Application Reference: 2025/0436

Site Address: 95 Strafford Avenue, Elsecar, Barnsley, S74 8AL

Introduction: Erection of 2 sheds to use as workshop and games room.

5.357
 150mm x 45 C24
 18mm OSB ZERO CLAD

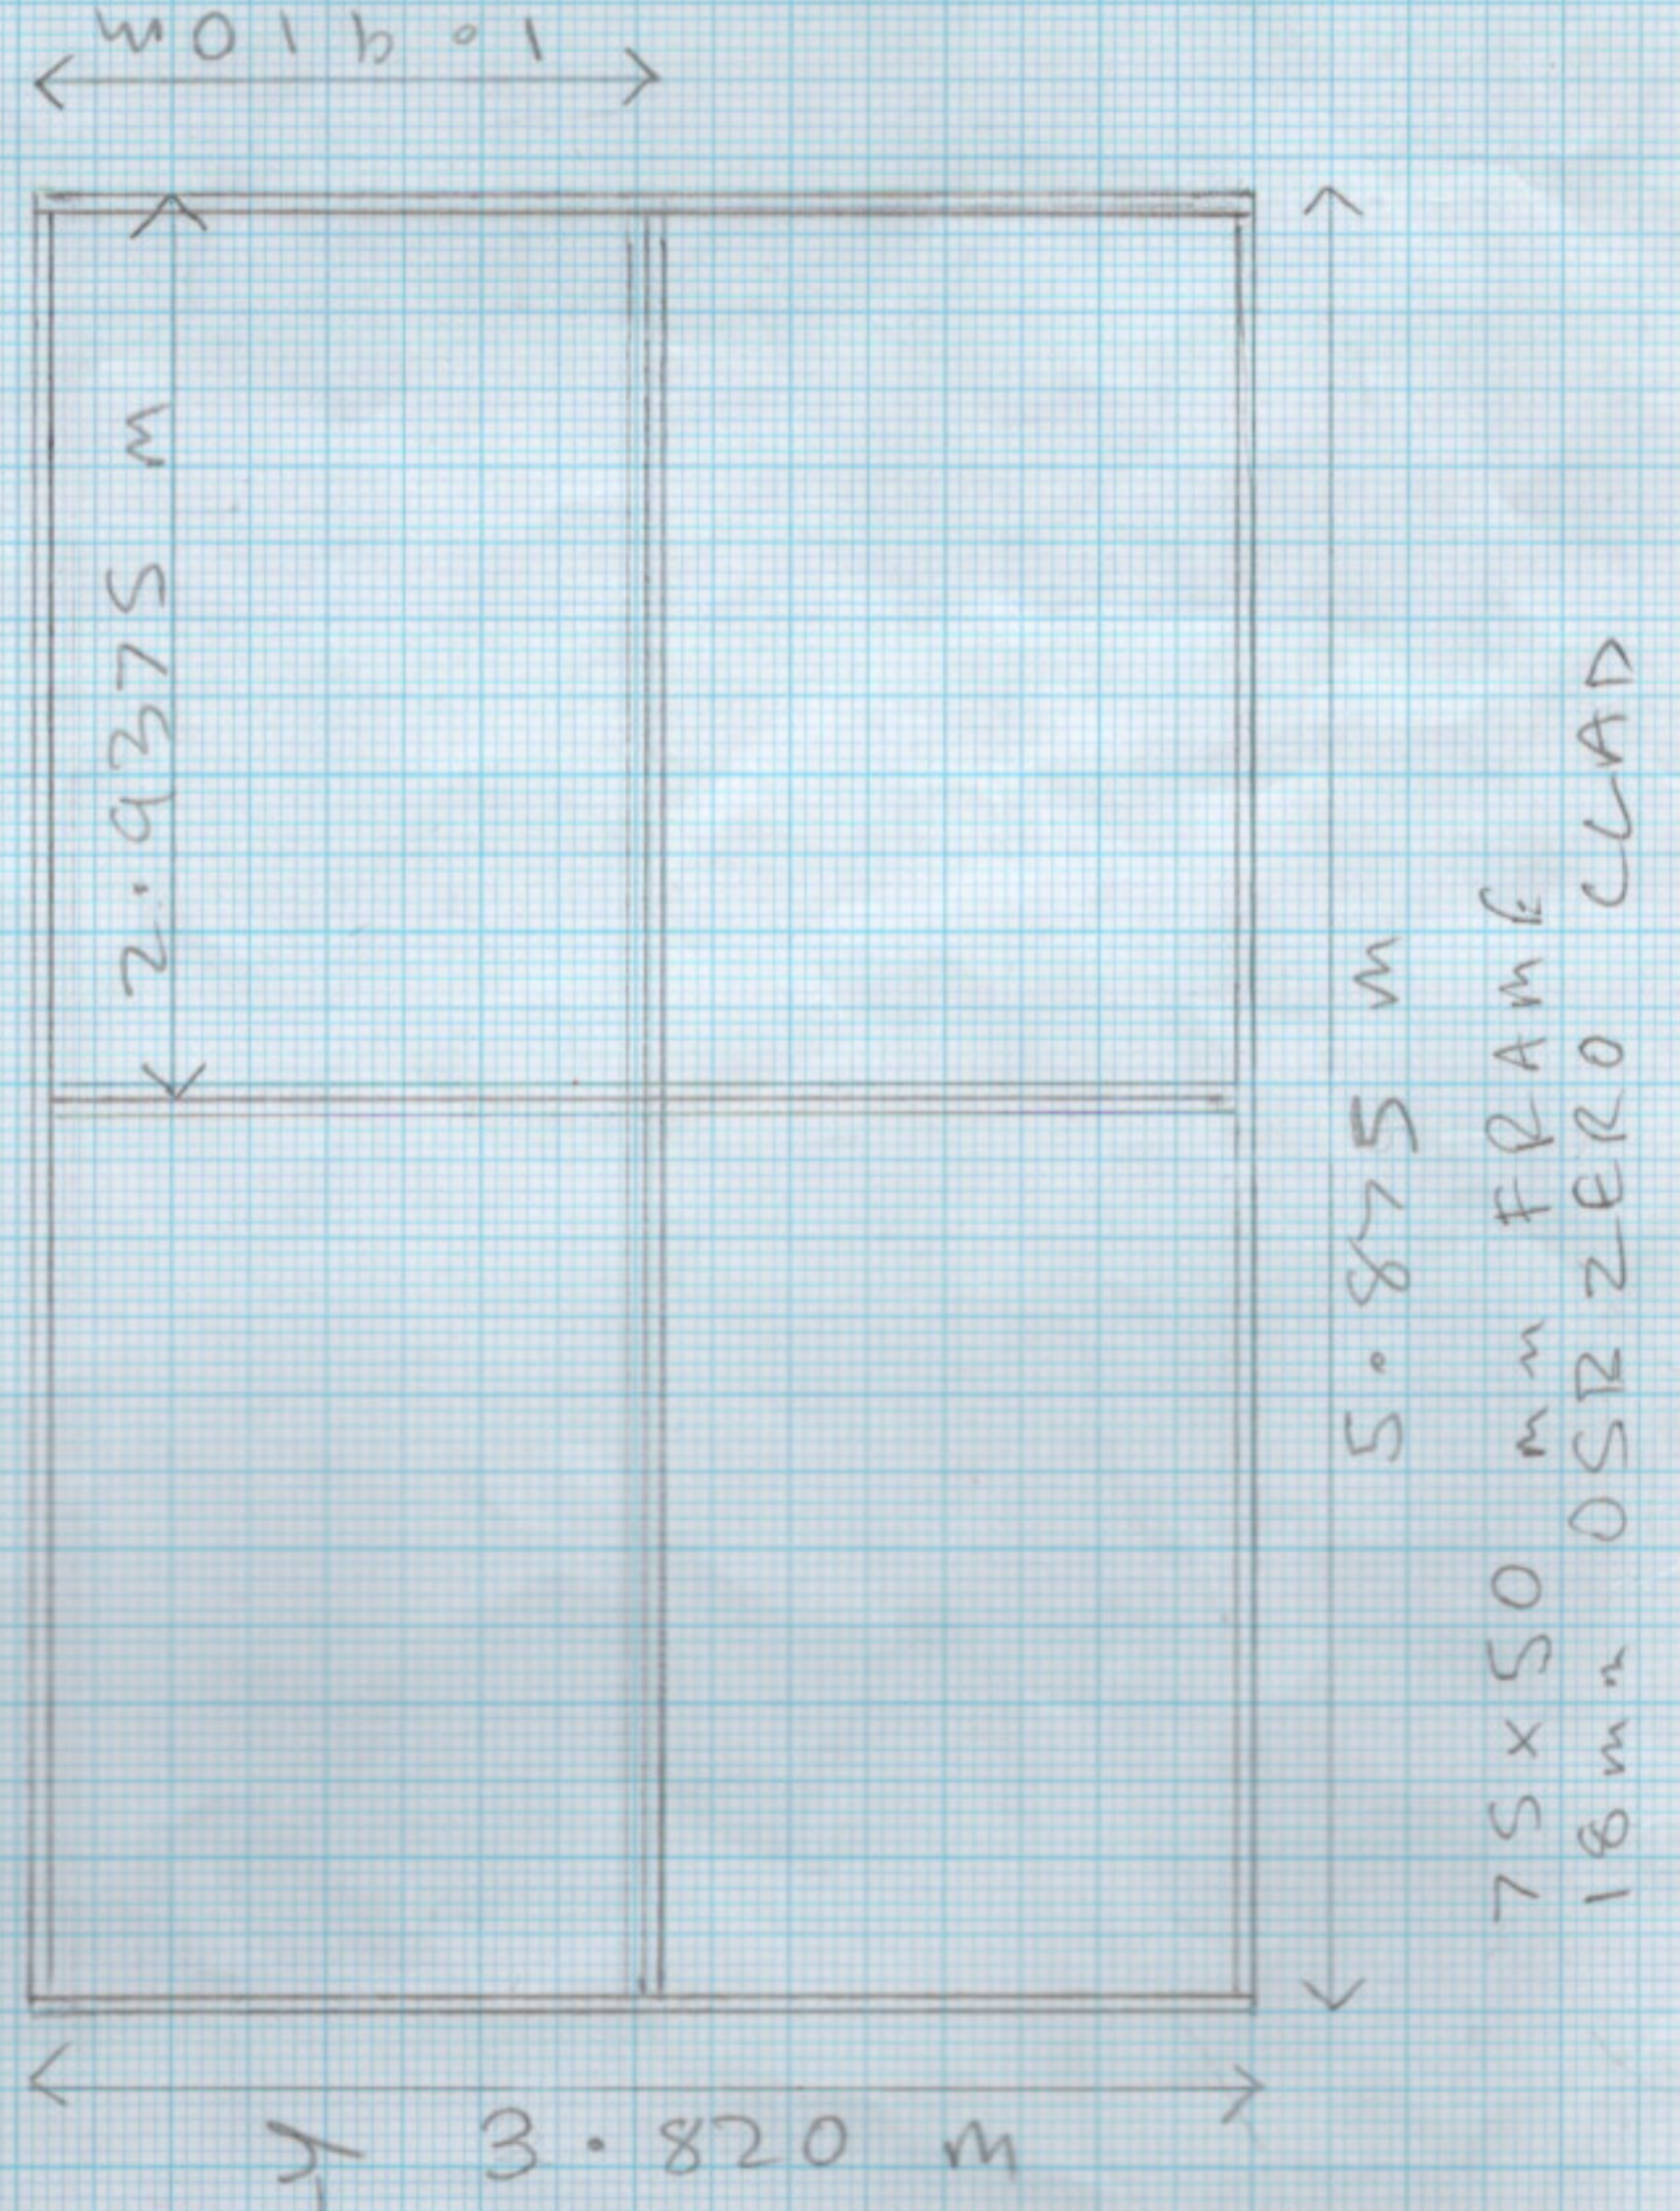
The applicant is seeking permission to erect two outbuildings. The New Workshop and the New Games Room. The New Workshop would have an approximate floor space of 22.3 square metres, an approximate total height of 2.77 metres and an approximate eaves height of 2.26 metres. A pitched roof has been detailed. Four elongated windows are detailed to the east elevation of the outbuilding, two either side of the proposed doors spanning 1.78 metres.

The proposed two proposed outbuildings would be erected within close proximity to the neighbouring boundary to the west. The size and scale of the outbuildings are not likely to cause any issues in terms of loss of light or outlook. The height of approximately 2.77 metres is less than the maximum 4 metres for outbuildings as outlined within the House Extensions SPD and the eaves heights of approximately 2.26 and 2.26 metres is also less than the maximum eaves height of 2.5 metres. These heights are not significantly greater than the existing boundary treatment and would not be impactful enough to cause detrimental harm to loss of outlook and sunlight.

The proposed new outbuildings are detailed to a scale in line with the House Extensions SPD. The height of approximately 2.77 metres is less than the maximum 4 metres outlined within the House Extensions SPD and the eaves heights of approximately 2.26 and 2.26 metres is also less than the maximum eaves height of 2.5 metres. The use of wood materials does not match the material of the site dwelling, however wooden sheds are common feature of residential gardens and are not considered detrimental to the character of the site, especially given they cannot be seen from the street scene.

The addition of the proposed new outbuildings would increase the cumulative floor space to approximately 81 square metres, approximately 69% of the total curtilage. Given the accumulation of the floor space taken up by the existing outbuildings and the proposed new outbuildings, it is considered the development at the site to be excessive and to take up a disproportionate amount of private rear garden space. It is acknowledged the erection of the two proposed outbuildings has begun but is not yet completed.

It has been necessary to make contact with the applicant to request plans and elevation of the proposed New Workshop and New Games Room in order to obtain more accurate roof and eaves heights for accurate assessment of the proposal. This information was provided and resulted in amended plans and elevations.

In the opinion of the local planning authority, the cumulative impact of the erection of two new outbuildings for use as a workshop and games room alongside several existing outbuildings would result in a disproportionate amount of the rear garden being developed. The cumulative impact of the existing and new development would also have an overtly dominant impact on the character of the application dwelling to the detriment of visual
